From: Jonathan Best <Jonathan.Best@arun.gov.uk>
Sent: 10 June 2026 15:54
To: Planning.Responses <Planning.Responses@arun.gov.uk>
Cc: Amber Willard <Amber.Willard@arun.gov.uk>
Subject: BN/64/26/PL

Hill View Eastergate Lane Eastergate PO20 3SJ.

I have reviewed this application with regards to ecology and Biodiversity Net Gain.

Recommendation: Hold for further information on protected species, bats and reptiles and BNG.

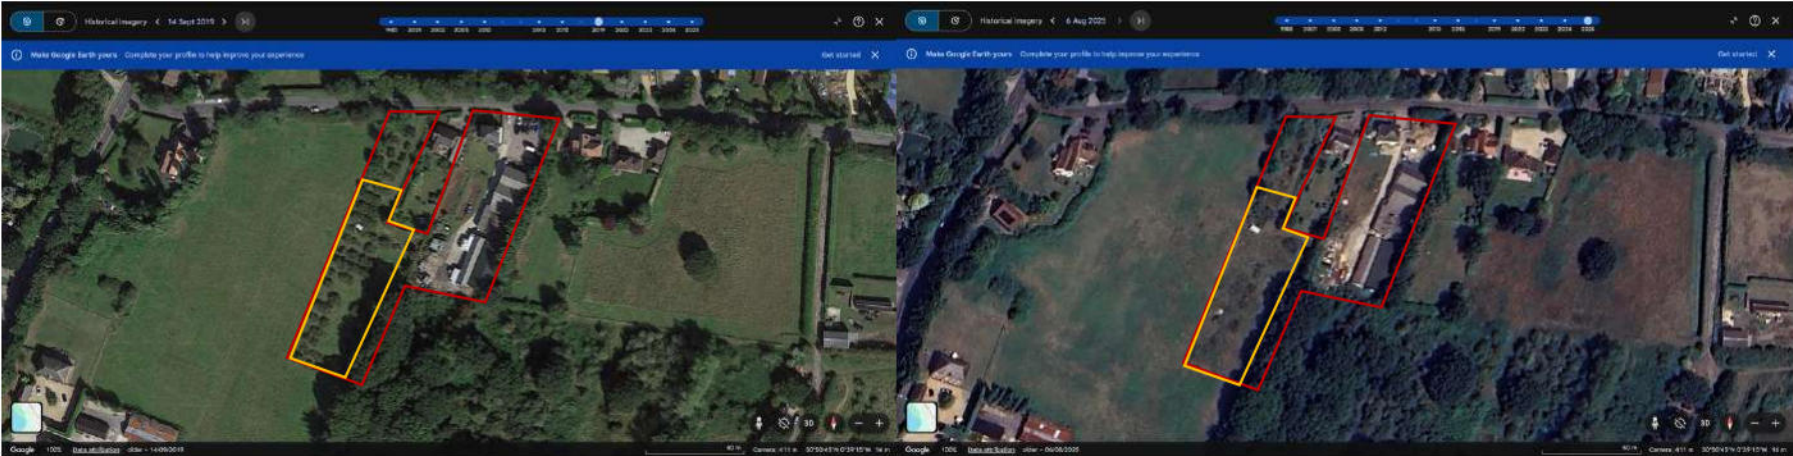
The metric indicates a loss of -1.56 area units equivalent to -17.29% based on current plans. Offsite BNG units will be required.

The BNG Metric may also be inconsistent with the revised development plans and the retention of orchard.

The post development plans do not show what habitats that will be present. There is no indication as to what areas are private gardens or other habitats is provided. It is impossible to fully assess and determine if the BNG information is accurate at this time. Clarification on the post development BNG is required.
